# KITITAS COUNTY DEPARTMENT OF PUBLIC WORKS

## County Survey review of Filbert Estates Short Plat 15-00004

FILBERT ESTATES SHORT PLAT
 PREPARED FOR
 HARLAN ODEGARD
 A PORTION OF THE N 1/2 OF THE NW 1/2 OF SECTION 29,
 TOWNSHIP 20 N., RANGE 14 E., W.M.

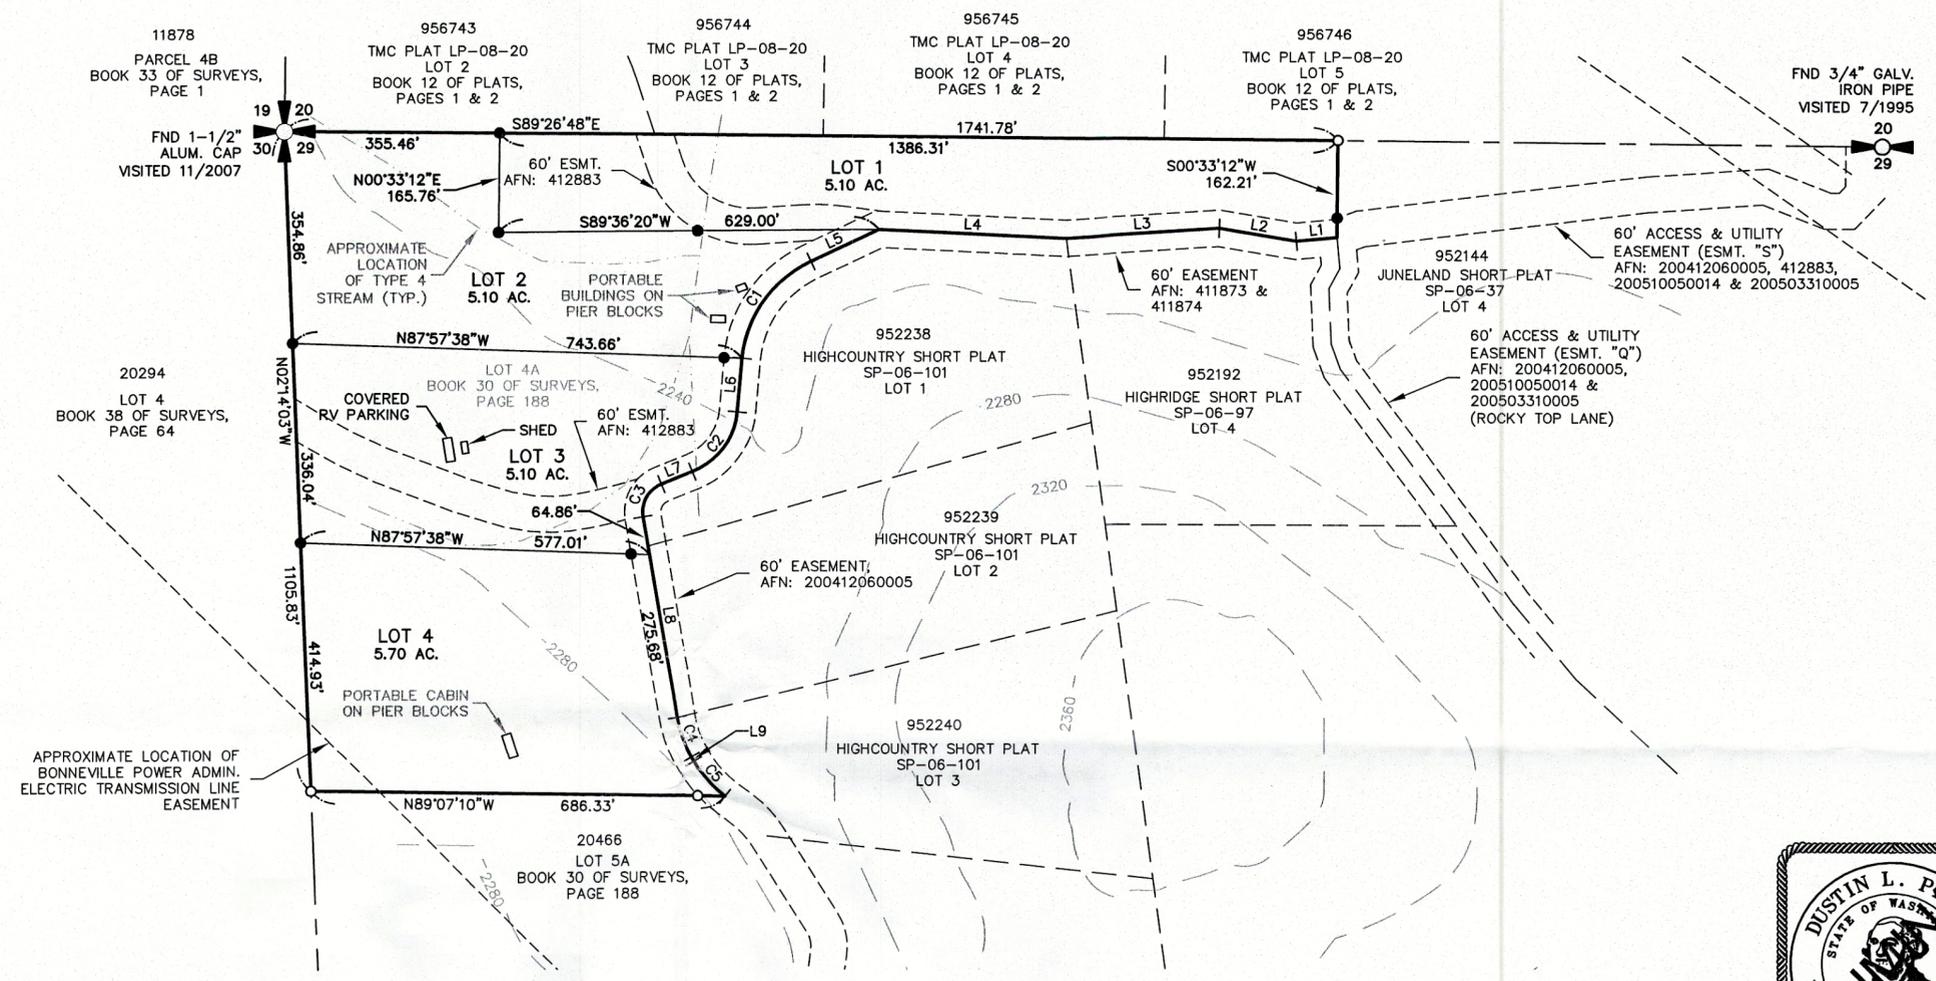
1. The Basis of bearing references an external document, which again references an external document etcetera. Change this to "Basis of bearing is the North line of the Northwest quarter of section, taken to be S89-26-48E, per that certain survey recorded in Book 30 of Surveys, Page188, or something similar.

2. Show a distance tie to the North quarter corner of section.
3. All easements shown need to display width, purpose and recording number. 411873, 411874, and 412883 need to show the easement type (Ex. Ingress and Egress, Access and Utility, Etc.)

4. All submittals showing contours must reference a Vertical Datum. (NGVD29, NAVD88, Assumed), *In this particular case, if Kittitas County ONLY requires the contours as part of their review process, contours can be removed prior to final submittal.*

5. Filbert Rd. and Rocky Top Ln. should be labeled as such with Name, Ownership (Private Easement), and surfacing material.
6. The legend should be changed to be more specific. Based upon BLA:30-188, "Found Iron Rod and Cap" should be changed to "found ½" Rebar/Cap "Nelson-18092"
